Residential Development, Cornelscourt, Dublin 18

Preliminary Design Stage Quality Audit

DBFL CONSULTING ENGINEERS

October 2019

REF: 'X1' LUMINAIRE
 PRELUX VALO 50W STREET LUMINAIRE
 6 METRE POLE MOUNTED X25

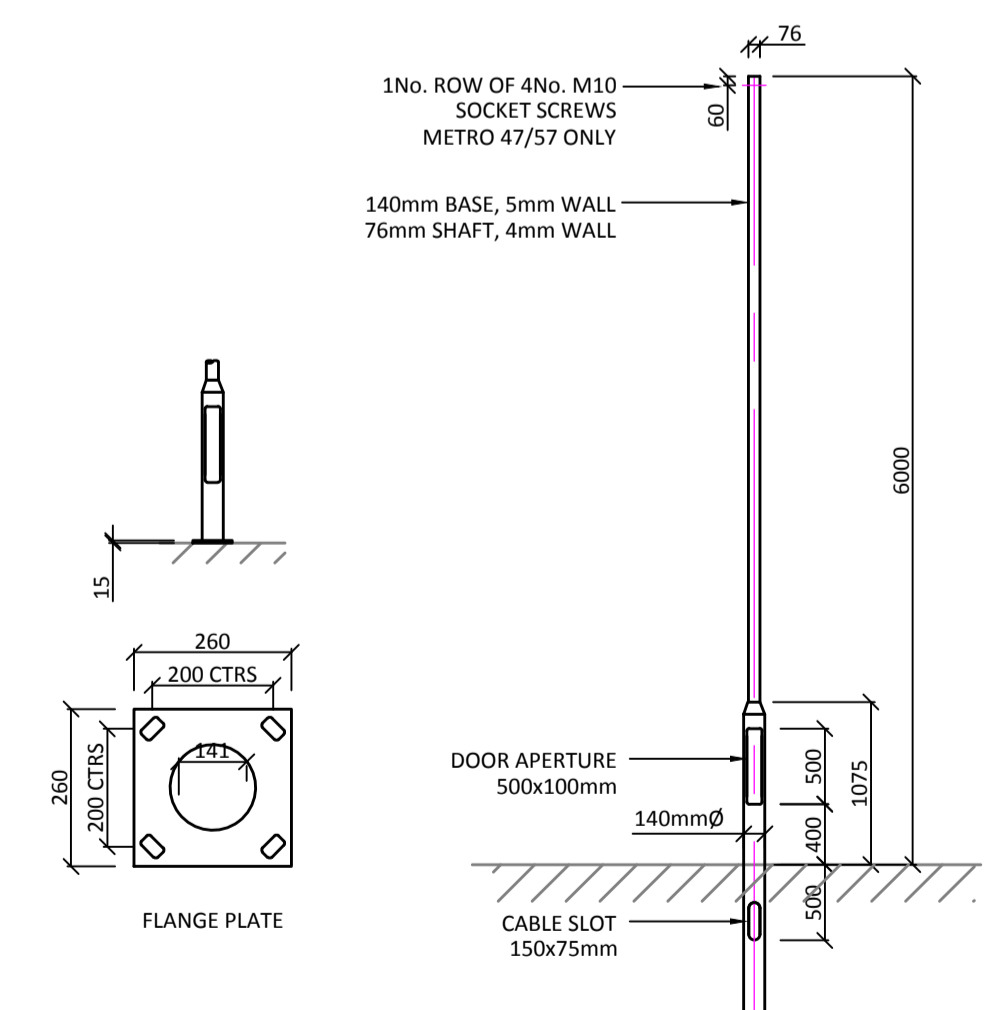
The drawings provided for the purpose of this audit do not detail the provision of street lighting along the pedestrian routes within the subject site. In the absence of appropriate street lighting, safety issues such as trip hazards could arise for pedestrians whilst personal security issues could prove a significant concern for pedestrians and cyclists.

During the detailed design stage, appropriate levels of internal lighting should be provided across all pedestrian, cyclists, and vehicle routes. The location of the street lighting columns should also be carefully considered to ensure that they do not impact access levels or present a hazard.
